Subject: 2 London Road Bognor Regis PO21 1QU - BR/301/20/PL

Planning Application Reference: BR/301/20/PL

Proposal: Alteration, conversion and partial demolition of existing building including the addition of 2nd floor extension to form 3 No one bed apartments with associated refuse & cycle storage. This site is in CIL Zone 4 (Zero Rated) as flats.

Drawing Title:
Proposed Floor Plans

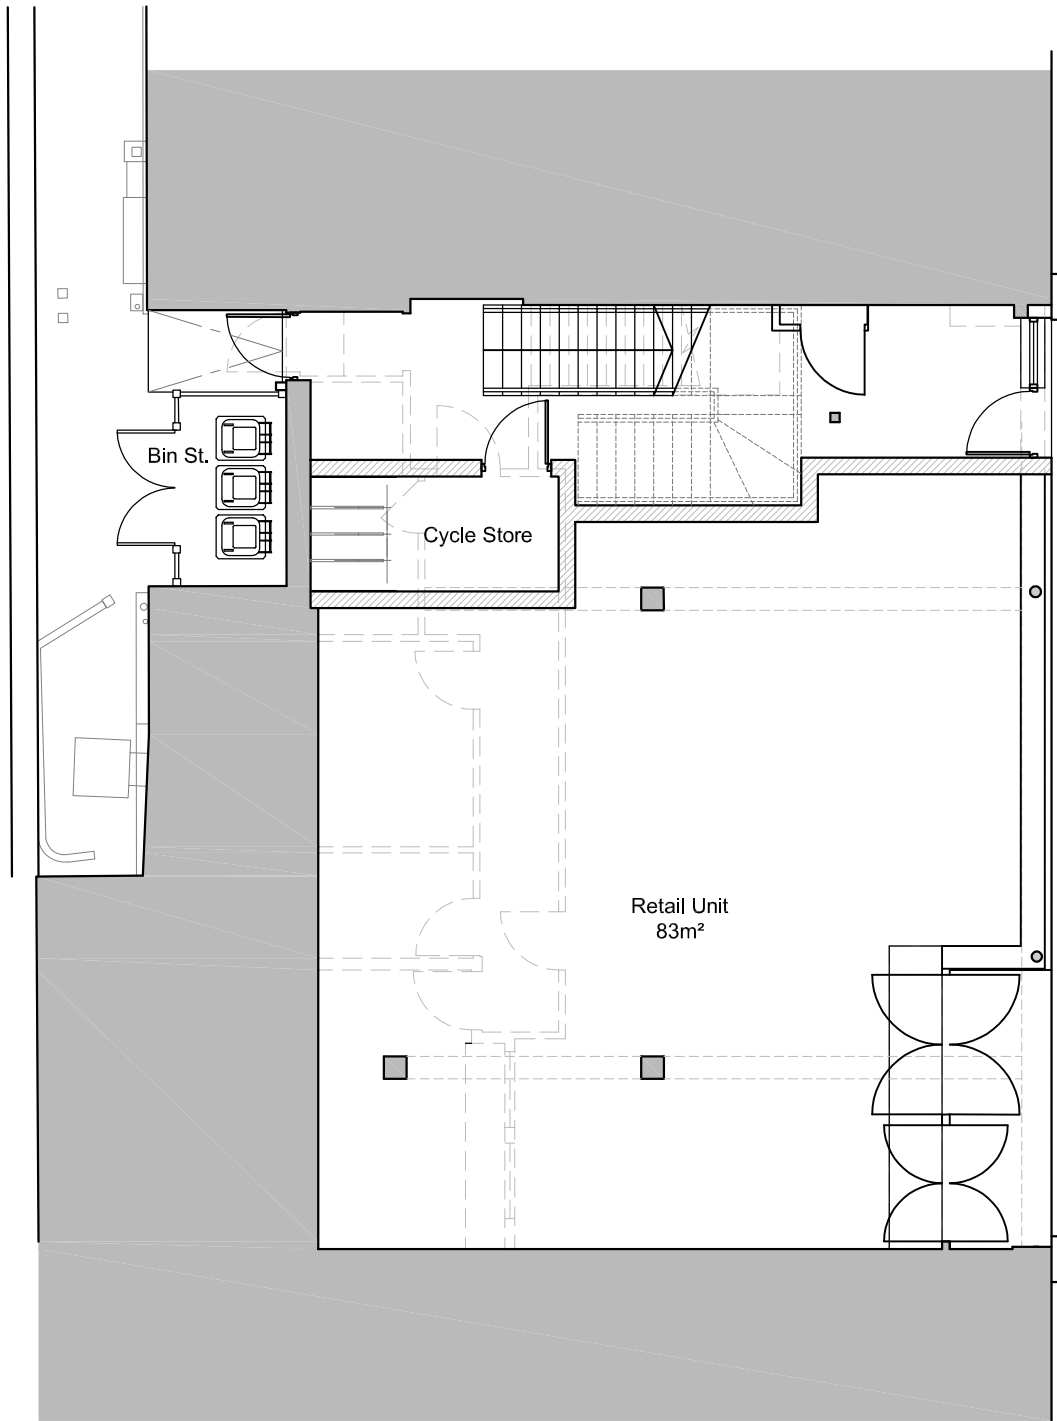
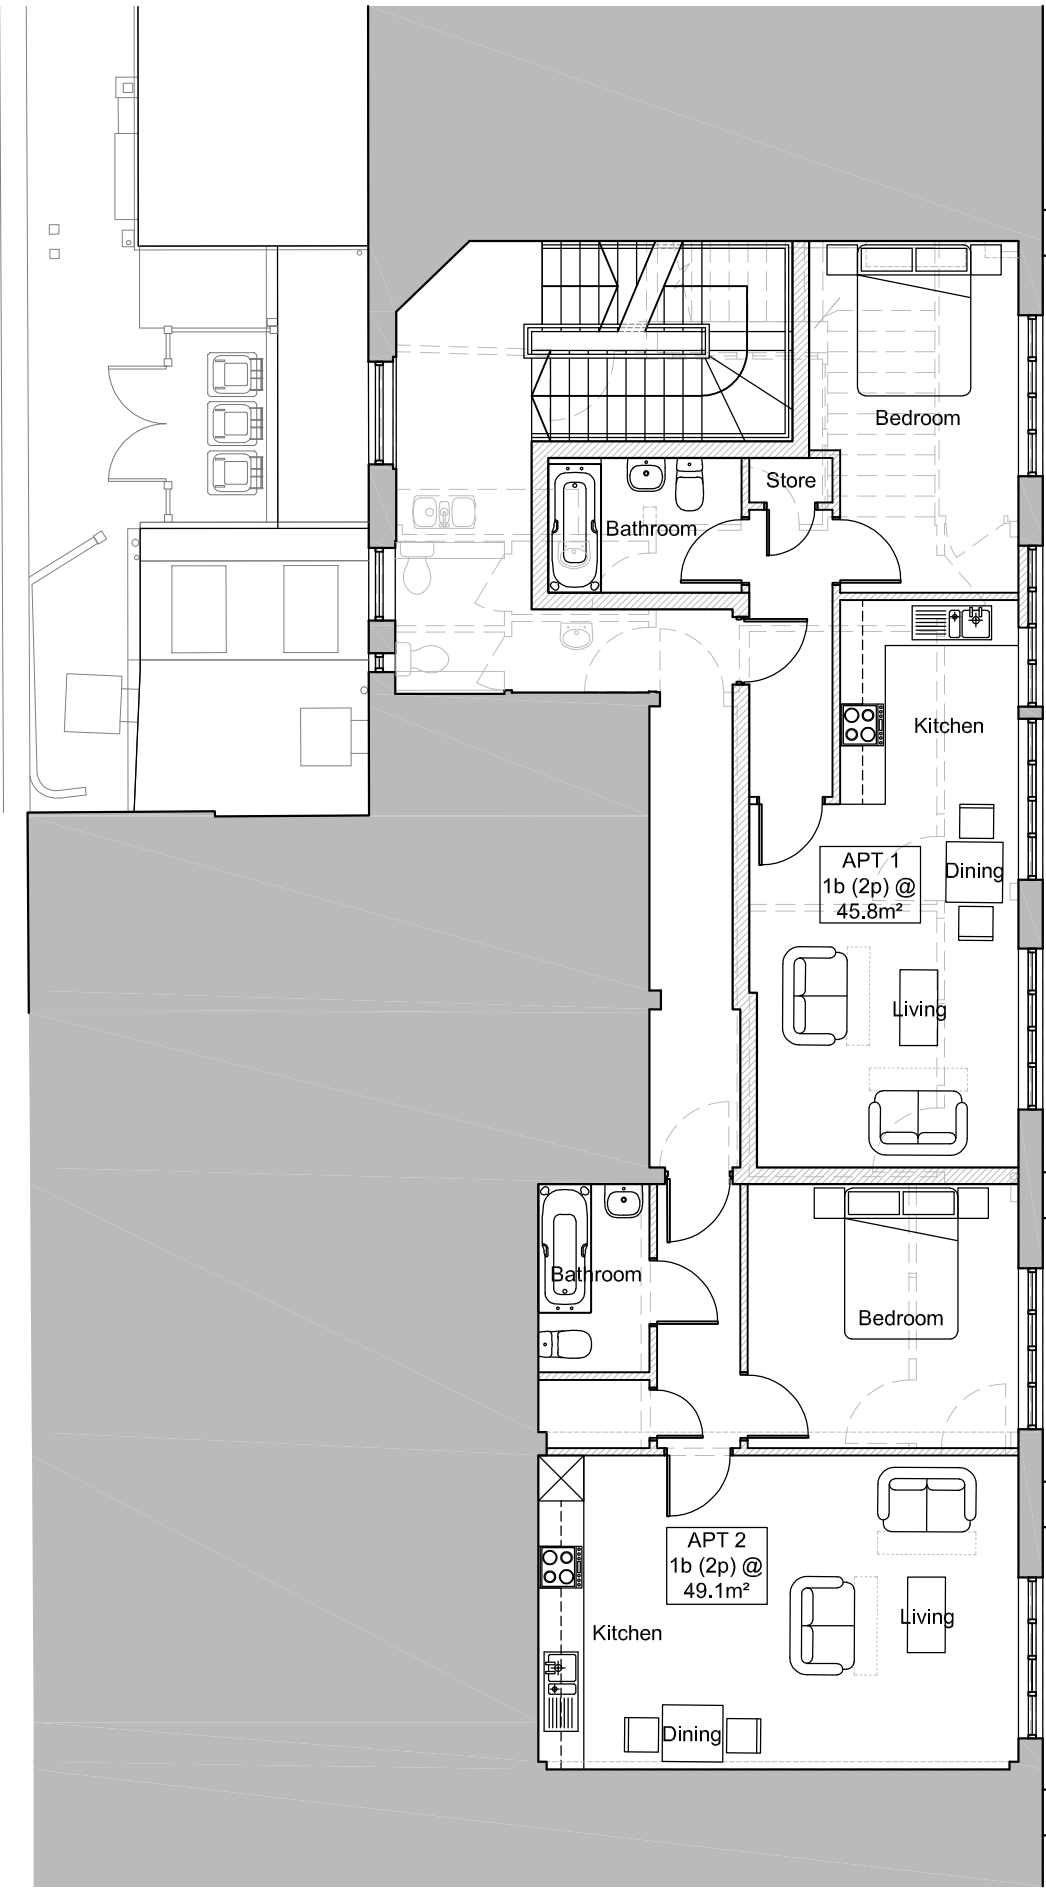
Floor/ceiling testing above proposed commercial unit

The sound insulation of the floor / ceiling between the ground and first floor shall achieve a minimum airborne sound insulation value of 50 dB ($D_{nT,w} + C_{tr}$). Before the residential unit is occupied, a test shall be undertaken by a competent acoustician and submitted to the Local Planning Authority to demonstrate compliance with this level.
